Application for approval of matters reserved by condition imposed under AW/211/14/PL relating to conditions 3, 6, 11 & 12 relating to window detailing, watercourse access & maintenance, Servicing Management Plan & pedestrian improvements.

The Ship Inn Aldwick Street Aldwick

Thank you for your internet representation made on 16th March 2015 which has been recorded as '**an objection**' with the comments as follows:

FRONT ELEVATION

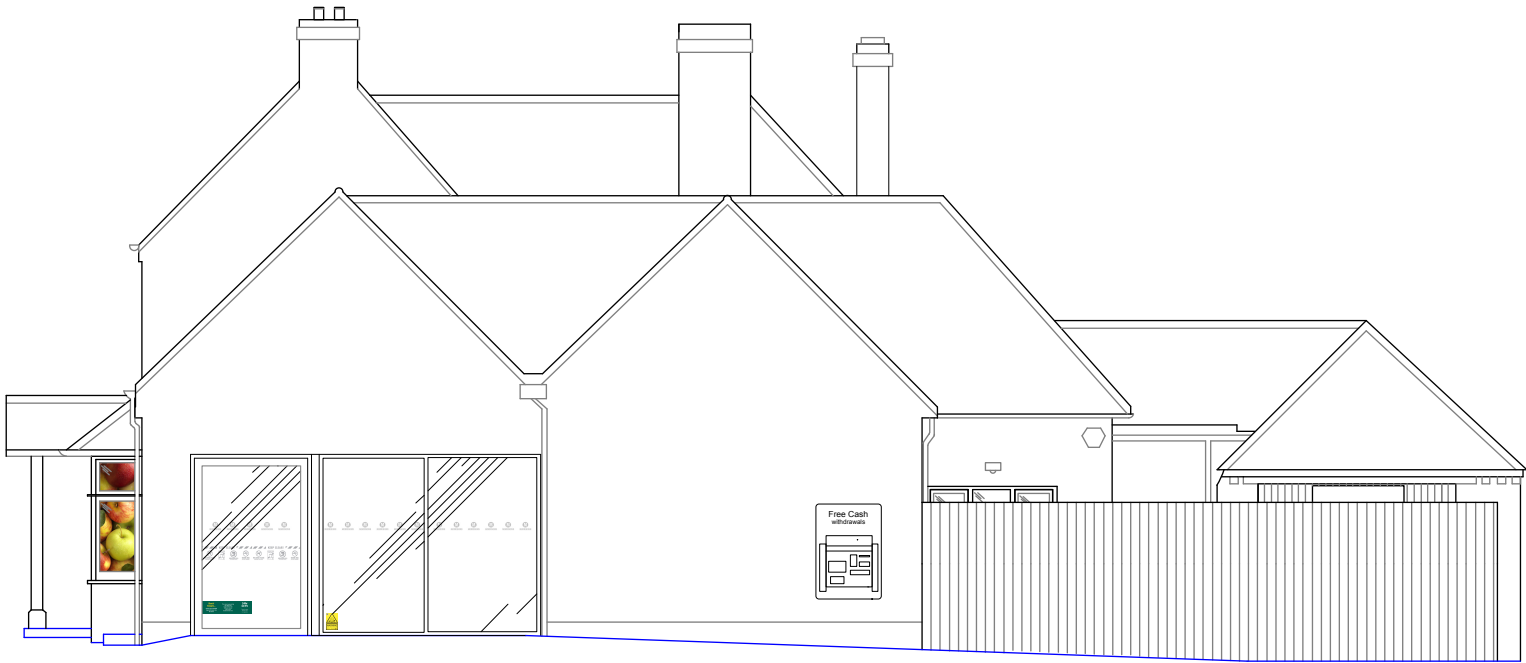
*Reference Condition 3 of approved application AW/211/14/PL, I do not believe that the applicant has made sufficient effort to get more acceptable window vinyls.
This condition cannot be discharged until the window vinyls have been approved and the current pictures of fruit and vegetables etc do nothing to enhance the nature of the building and area. They are totally out of character and the applicant should be advised to reconsider.
Historic pictures such as those submitted with the application are commonly seen in much larger sizes so it must be possible to obtain them.
I urge that the LPA do not approve this aspect of the application.*
